2024/0855

High Royd House, High Royd Lane, Hoyland, Barnsley, S74 9NW

Conversion of integral garage, first floor extension over the existing single storey garage and erection of a porch to create an annexe. Creation of additional parking spaces, following demolition of existing outbuilding. (Resubmission of 2024/0518).

SHEET NAME Proposed Plans

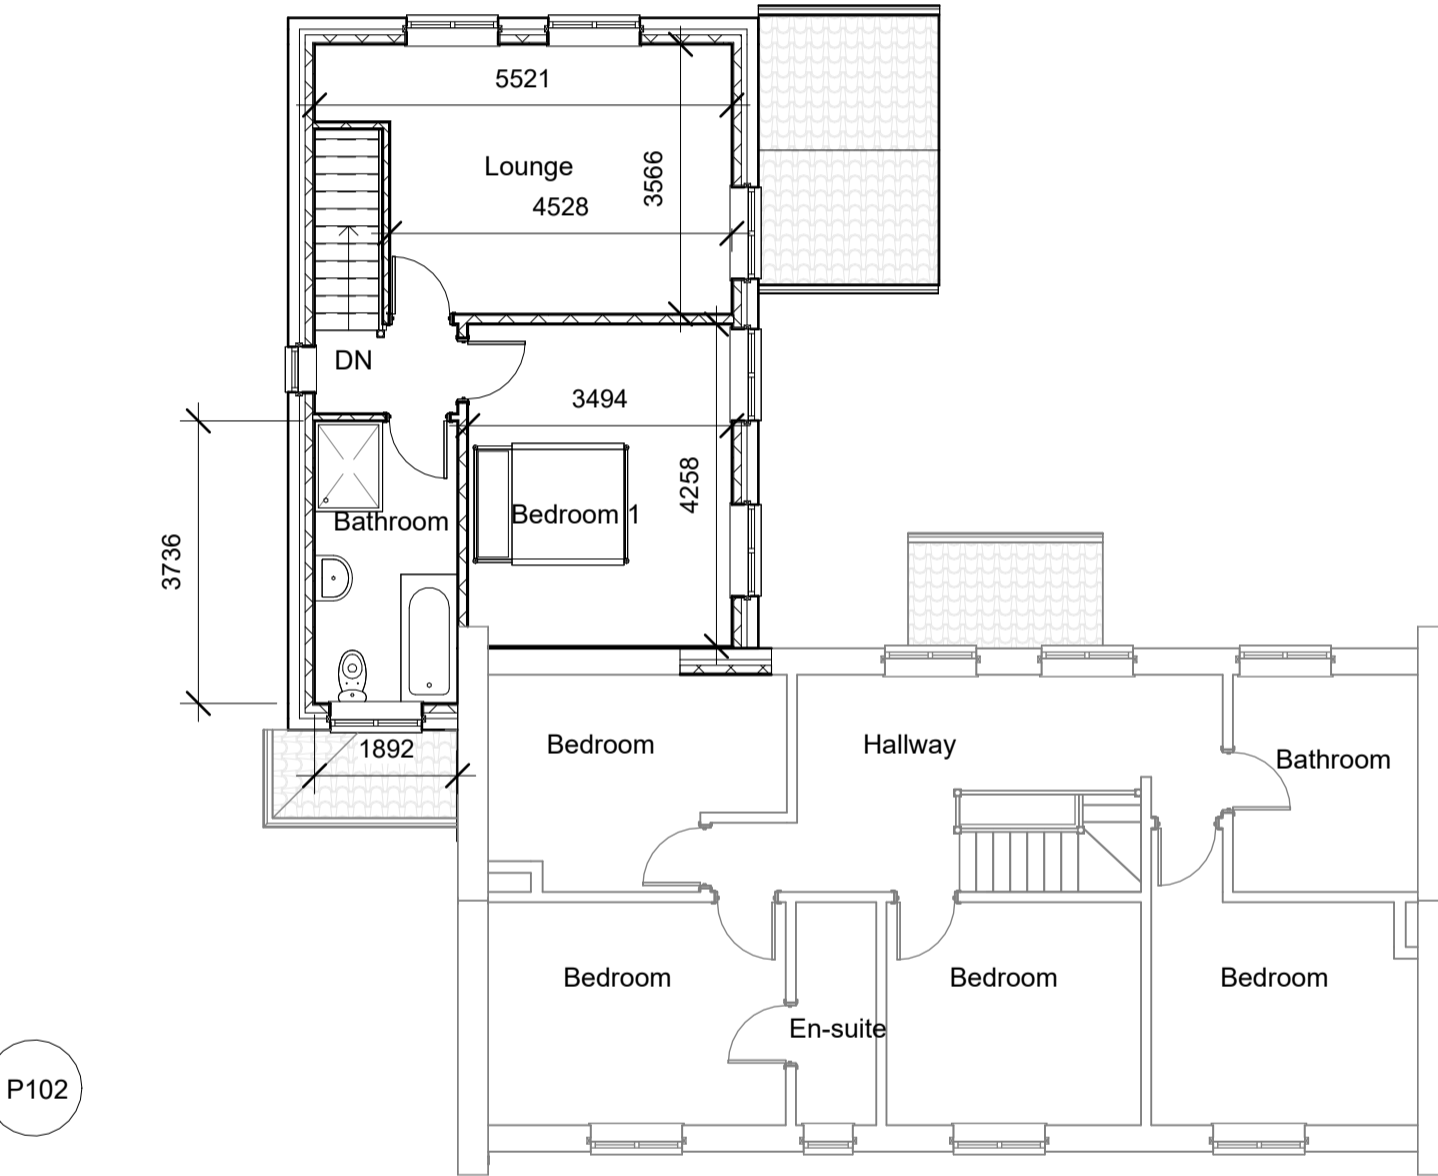
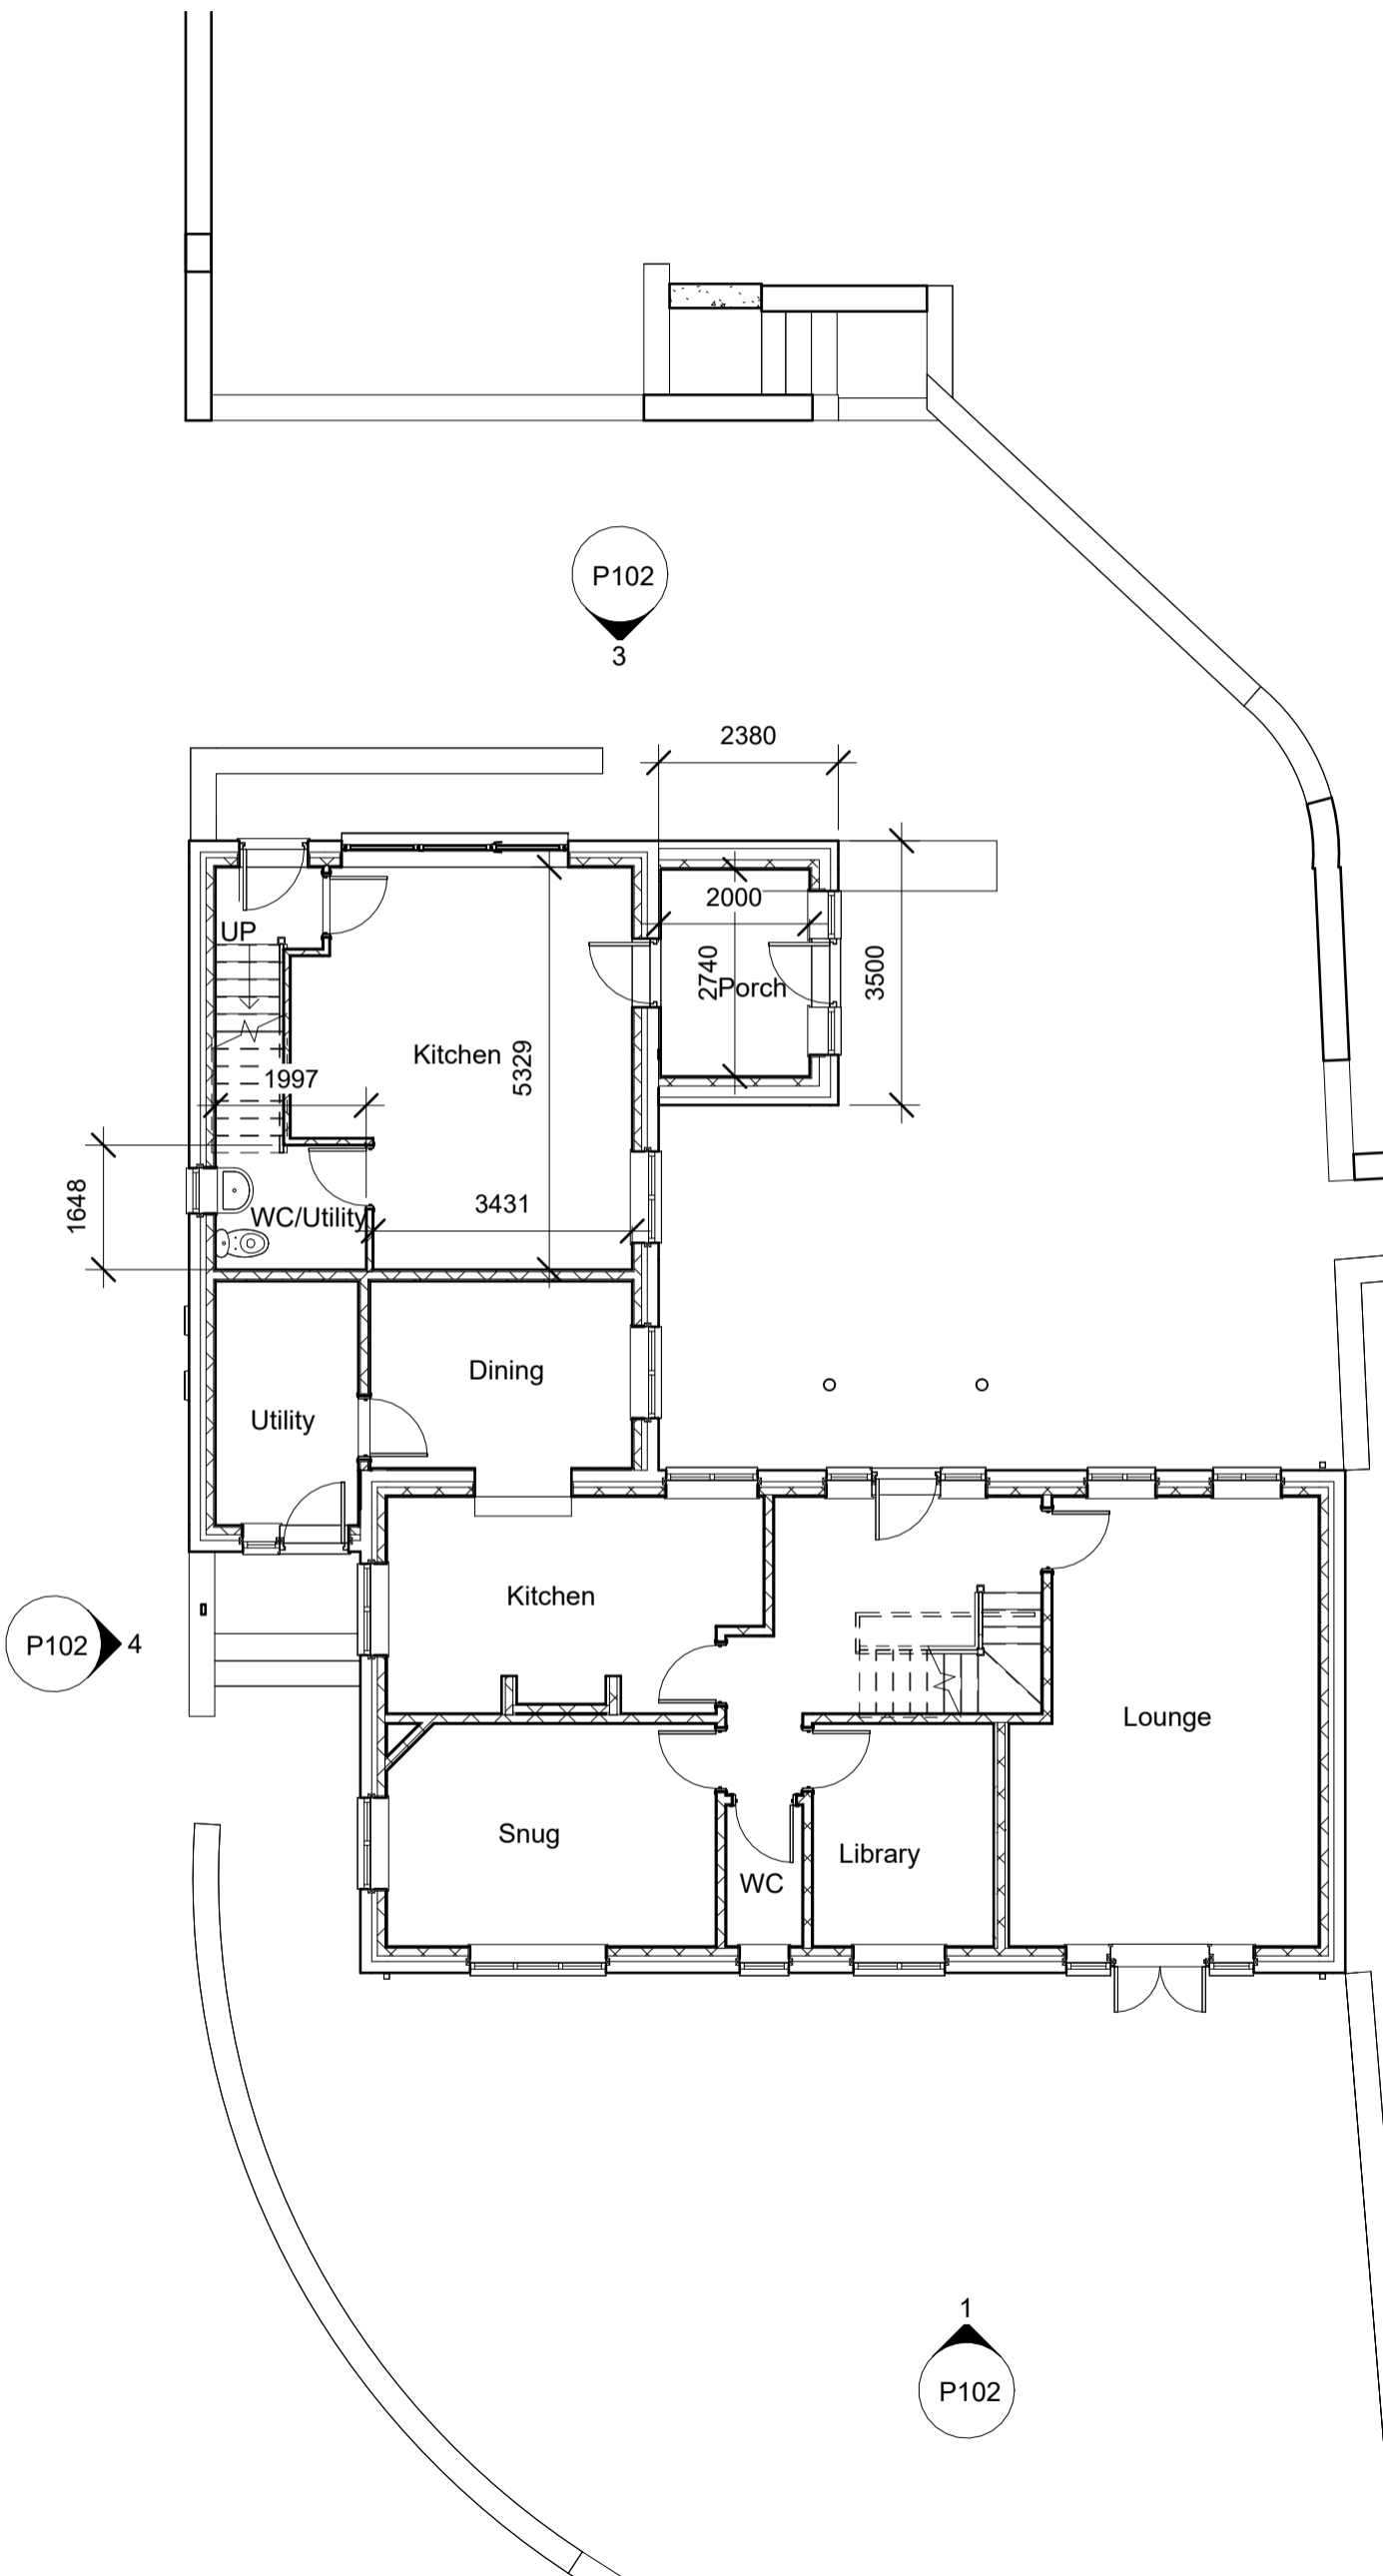
The proposed conversion of the existing garage to habitable space would see it comprise of a kitchen and WC at ground floor level. The proposed first-floor extension would maintain the footprint of the existing garage and would have the appearance of a two-storey extension with a total approximate eaves and ridge height of 5.3 metres and 7.2 metres respectively. The first-floor would comprise of a bedroom, bathroom and lounge. The proposed porch would be located on the south-east elevation and would measure approximately 2.4 metres by 3.5 metres. The proposed porch would adopt a gable pitched roof with an approximate eaves and ridge height of 2.5 metres and 3.7 metres respectively. The proposed first-floor extension and porch would be constructed of closely matching external materials. An existing outbuilding to the western rear corner within the application site would be demolished and 4no. parking spaces would be created.

It is acknowledged that the proposed annexe would not fully comply with the guidance set out within the House Extensions and Other Domestic Alterations SPD, specifically that its internal floorspace (approximately 59m²) would exceed 39m² and would be more accustomed to the floorspace normally permitted for a 1-bedroom 2-person dwelling as set out by the SYRDG. However, this is considerably

reduced from the 140m² proposed under application 2024/0518. Moreover, the proposed annexe would be contained within the existing footprint of the application property and would be attached to the main dwelling. A close physical relationship would therefore be achieved. The proposal would also adopt the appearance of a two-storey extension and would not significantly alter or detract from the character of the application property or wider street scene. The proposal, including the proposed porch, would also adopt a sympathetic form and features, including a gable pitched roof and closely matching external materials.

The proposed ground floor window located on the north-west facing elevation of the existing garage projection that would serve a WC, and the proposed first-floor window located on the south-west facing elevation of the first-floor extension that would serve a bathroom, will be conditioned to be obscure glazed in the interest of privacy and in accordance with Local Plan Policy GD1.

SHEET NAME Proposed Elevations

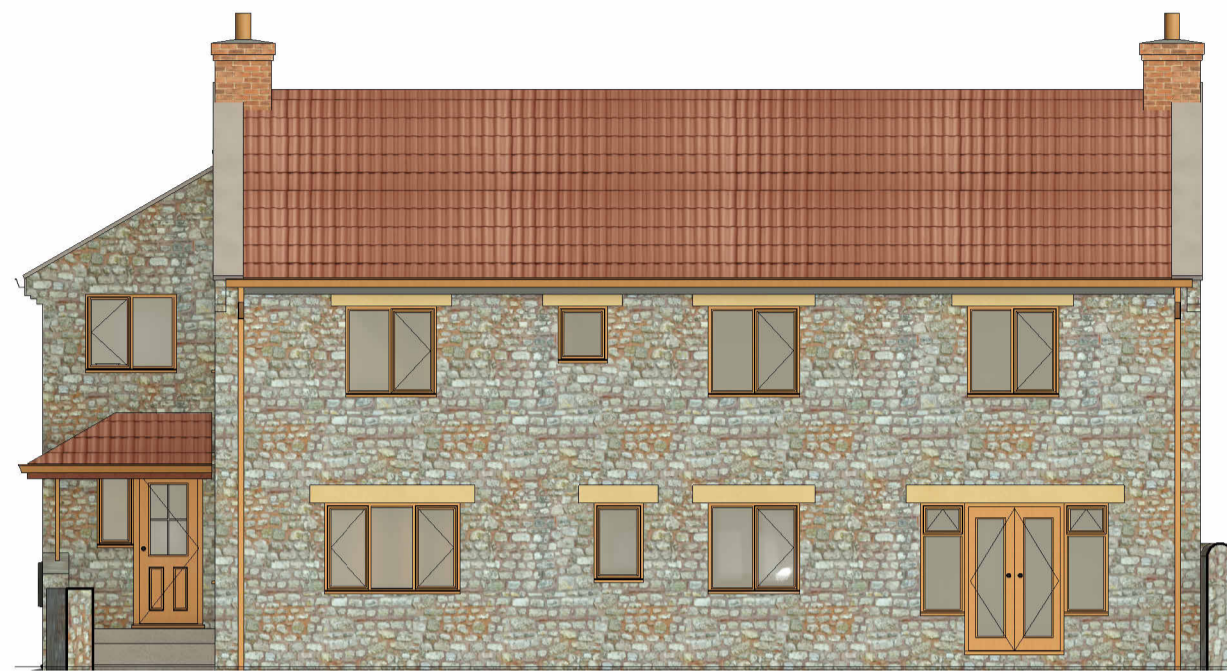
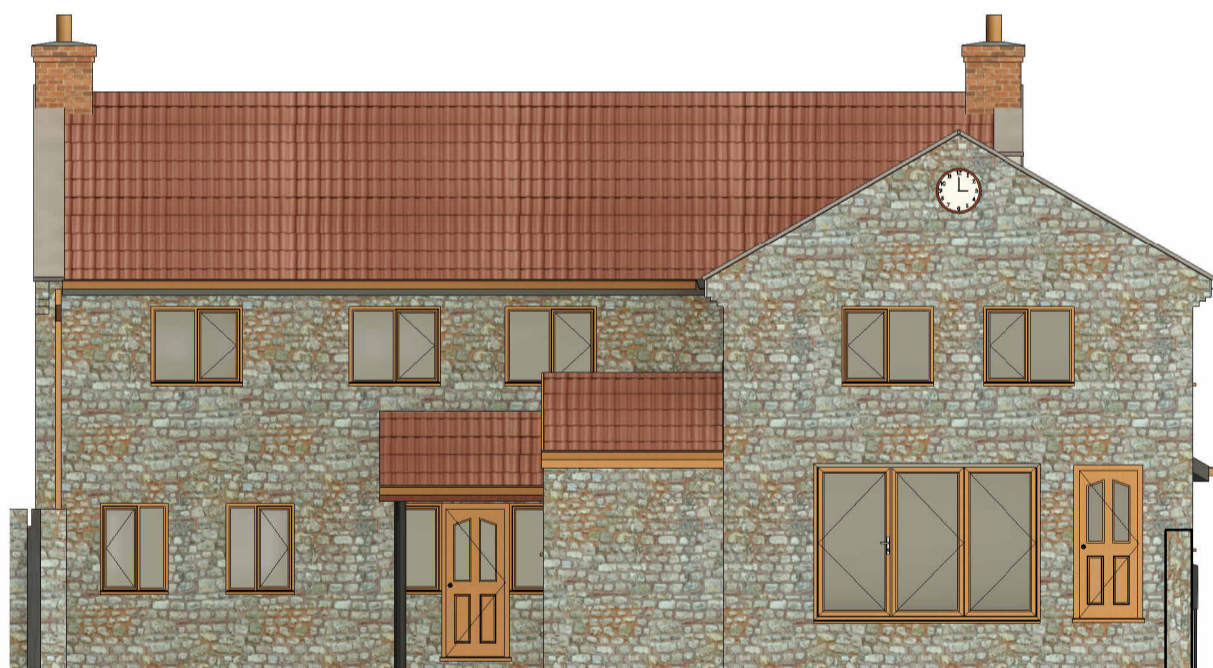
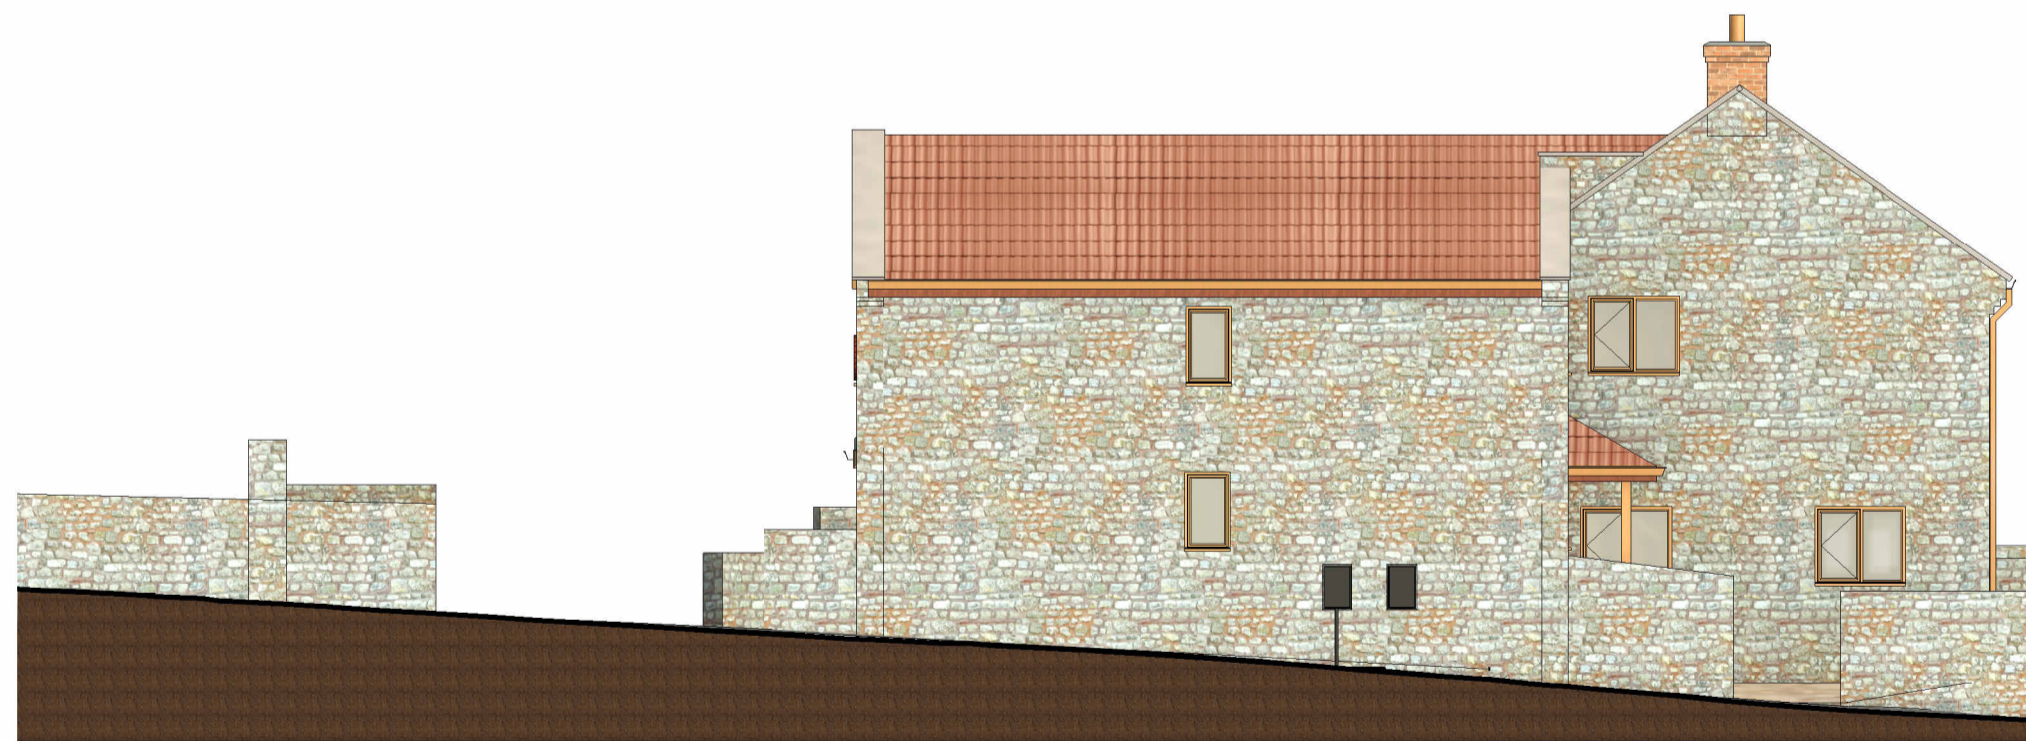
The proposal has implemented most of the previously suggested amendments, which is welcome. The proposed first-floor extension has been maintained, but its size has been greatly reduced and confined to the existing footprint, which alongside the setting of the roof below the ridge of the main dwelling, would appear subservient. A new porch extension has also been proposed.

The proposal includes first-floor windows located on all elevations. The south-west facing non-habitable room window of the first-floor extension would face towards an area of trees immediately opposite. The south-east facing habitable room windows of the first-floor extension would face into the application site and towards nearby agricultural buildings shown to also be under the applicant's ownership. At least 21 metres would be achieved between the north-west facing non-habitable room windows of the development and the habitable room windows of the dwellings opposite, and the north-east facing windows and the nearby neighbouring residential curtilage, which is an acceptable separation distance. A replacement first-floor habitable room window on the north-west facing gable elevation of the main dwelling serving a bedroom would maintain residential amenity and achieve adequate access to natural light and levels of outlook. At least 21 metres would be achieved between this window and the habitable room windows of the dwellings opposite, which is acceptable.
